From: Hebe Smith
Sent: 16 October 2026 14:46
To: Planning Scanning
Subject: FW: LU/157/26/PL - Wick Football Club

From: Darryl Kelly [REDACTED]
Subject: LU/157/26/PL - Wick Football Club
Date: 6 October 2026 at 16:39:25 BST
To: Neil Boddington <[REDACTED]>, Katherine Rose [REDACTED]
Cc: Nathaniel Leney at S&C Slatter Ltd [REDACTED]

DRAINAGE PLAN

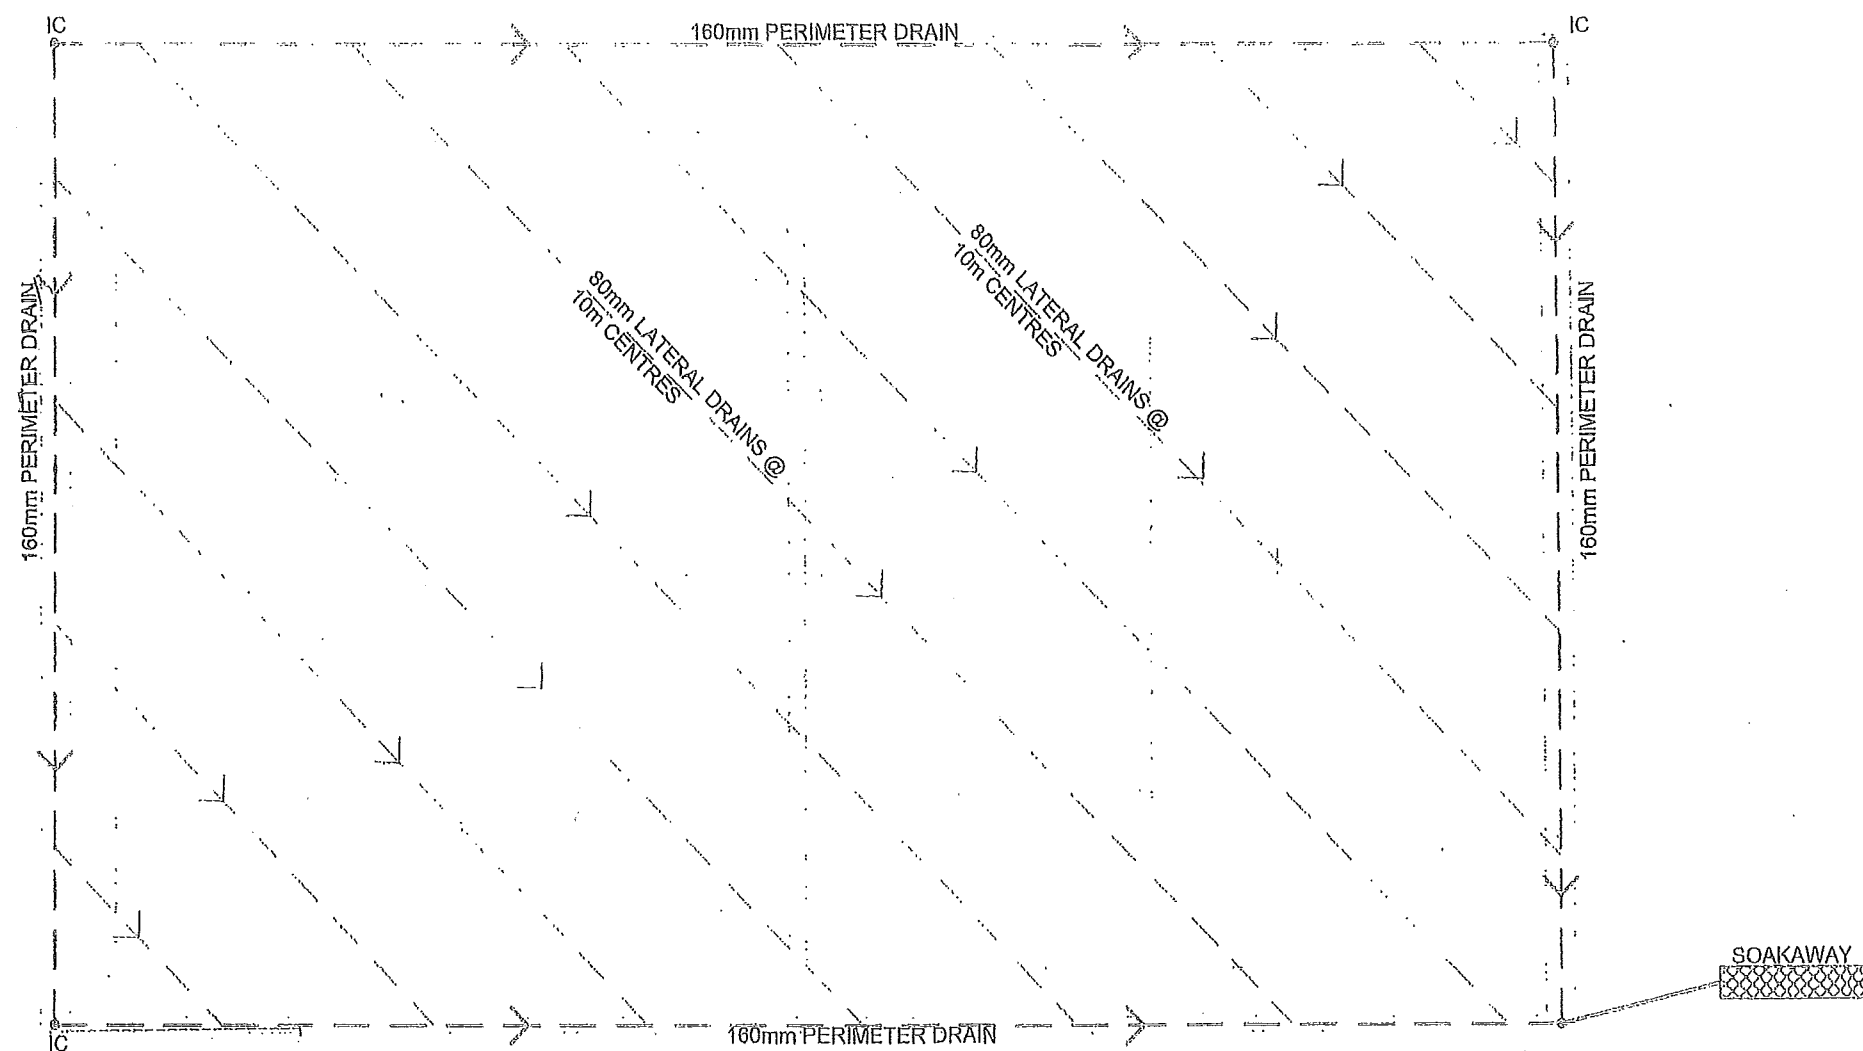
1. The Council has acknowledged that discharge to the surface water sewer represents an acceptable alternative where infiltration is demonstrated to be unsuitable, and has indicated that any further ground investigation could potentially be dealt with by condition on this basis.

3. Indicative infiltration testing at 1.0 m bgl demonstrated that the shallow cohesive River Terrace Deposits are effectively impermeable. The Council has suggested that potentially permeable soils may occur at approximately 1.5–2.0 m bgl; however, our investigation generally encountered cohesive River Terrace Deposits to depths of approximately 1.5–2.3 m bgl, beneath which more permeable granular deposits were encountered.

4. More importantly, our investigation identified evidence of potential chalk dissolution features. Consequently, we have recommended that the proposed pitch incorporates a sealed base to minimise uncontrolled infiltration and that surface water is directed to a positive drainage outfall. Concentrated infiltration into the underlying granular deposits/chalk could create or reactivate dissolution features and consequently increase the risk of ground instability.

5. Whilst our report acknowledges that further BRE 365 compliant testing would be necessary if soakaways were to be pursued, it also recommends that any infiltration system is located remote from the pitch and at least 20 m from foundations, structures and boundaries due to the identified dissolution risk. Given the site constraints, there appears to be limited practical opportunity to accommodate such a system.

On this basis, I would question whether further infiltration testing and winter groundwater monitoring would materially alter the drainage strategy. Even if suitable infiltration rates and groundwater clearance were demonstrated, the identified chalk dissolution risk would remain and would continue to make concentrated infiltration undesirable from a geotechnical perspective.

We therefore consider there is sufficient site-specific engineering evidence to justify progressing with the proposed positive drainage solution to the existing surface water sewer, subject of course to confirmation of sewer capacity, levels and the necessary approvals.
